From: Guy Dixon [REDACTED]
Sent: 25 May 2021 12:18
To: Michael Eastham <Michael.Eastham@arun.gov.uk>
Subject: RE: AB/135/20/OUT - Land at Ford Road, Arundel

Further to our discussion this morning on the cycle permeability through the site I write to confirm that we are happy for a planning condition to be imposed requiring the provision of a cycle path from the site onto Priory Lane. I would suggest the following wording.

Figure 2 Illustrative Masterplan

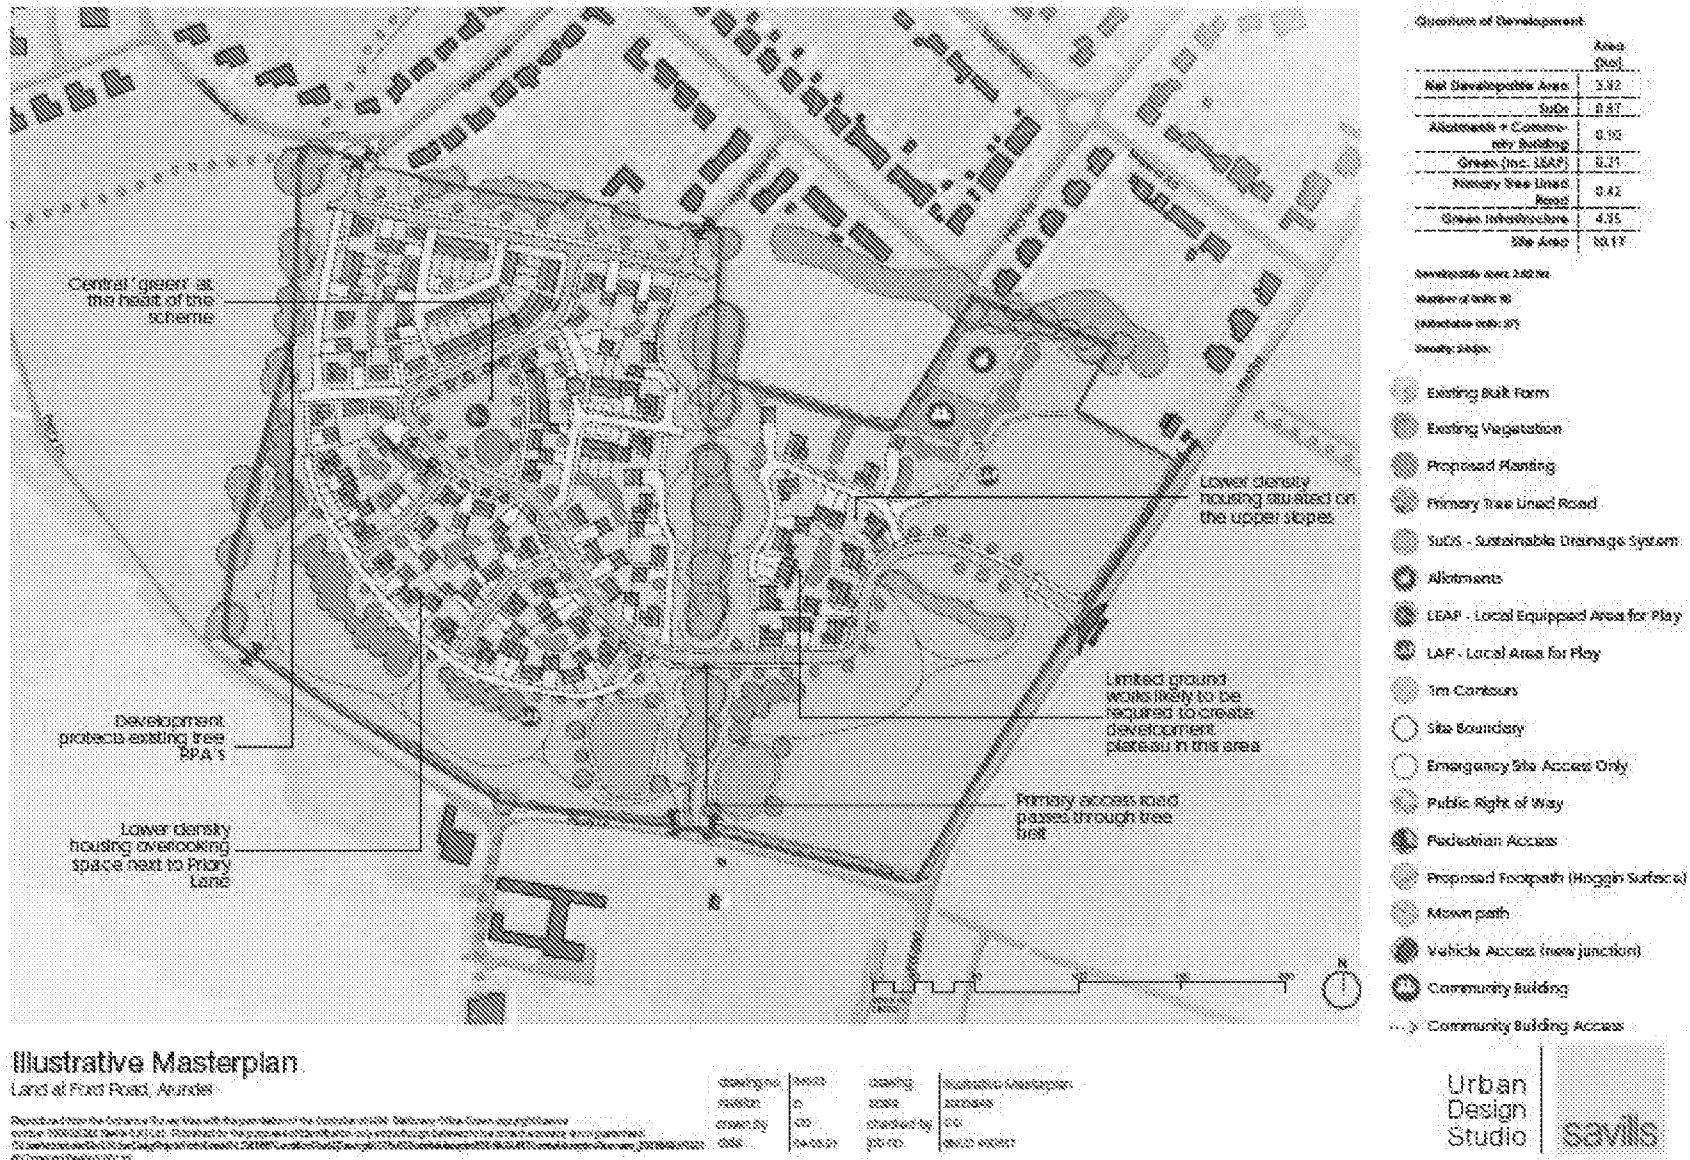
In respect of linkages onto High Ridge Close this was already shown on the illustrative masterplan and can be further detailed at the reserved matters stage.

Notwithstanding the illustrative masterplan layout submitted, details of a cycle path leading south west from the development site onto Priory Lane shall be included within the final layout submitted at the reserved matters stage and this cycle path shall be retained in perpetuity.
